Technical Memorandum

To:	John Woods
From:	John Knutson, PE URS Corporation 3810 Kern Rd., Suite A Yakima, WA 98902 (509) 469-0163
Copies:	File
Date:	July 29, 2014
Subject:	Review and Comments on Flood Study for Black Horse
Project:	33764776—Bender Road Flood Review

Flooding for existing conditions

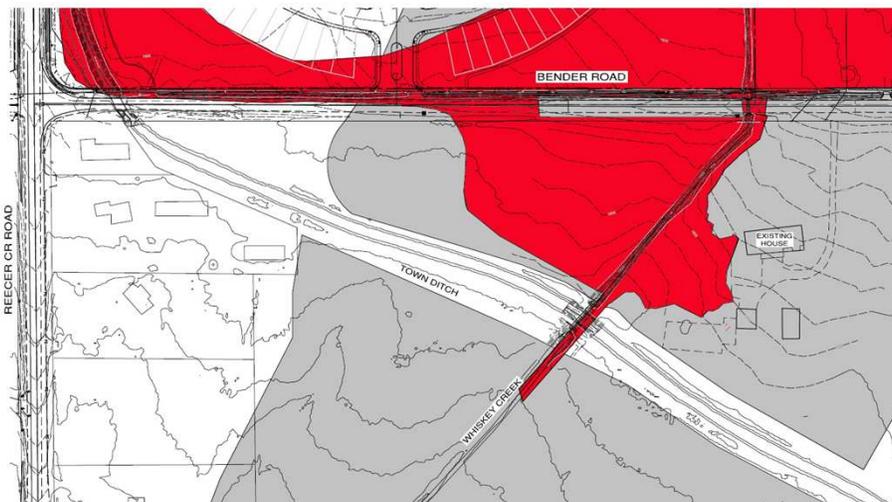
- The proposed condition floodplain on the west side of Whiskey Creek on the Woods property is stated to be much smaller than the existing condition (Anchor Memo Page 3). This is not correct. The actual existing condition floodplain on the west side of Whiskey Creek is much smaller than proposed conditions.

- The assessment of the increase in floodplain on the east side of Whiskey Creek on the Woods property (Anchor Memo Page 3) is effectively minimized because the existing condition mapping is incorrect. There is far less floodplain on the east side of the creek on the Woods property than depicted on the Anchor existing condition maps.

- 4) The topography of Whiskey Creek and its floodplain downstream of the canal undershot looks similar to the upstream side, yet Anchors proposed condition floodplain map shows a much narrower width of floodplain downstream of the canal. Why is this? Is the creek channel much deeper/wider and steeper than above the canal?
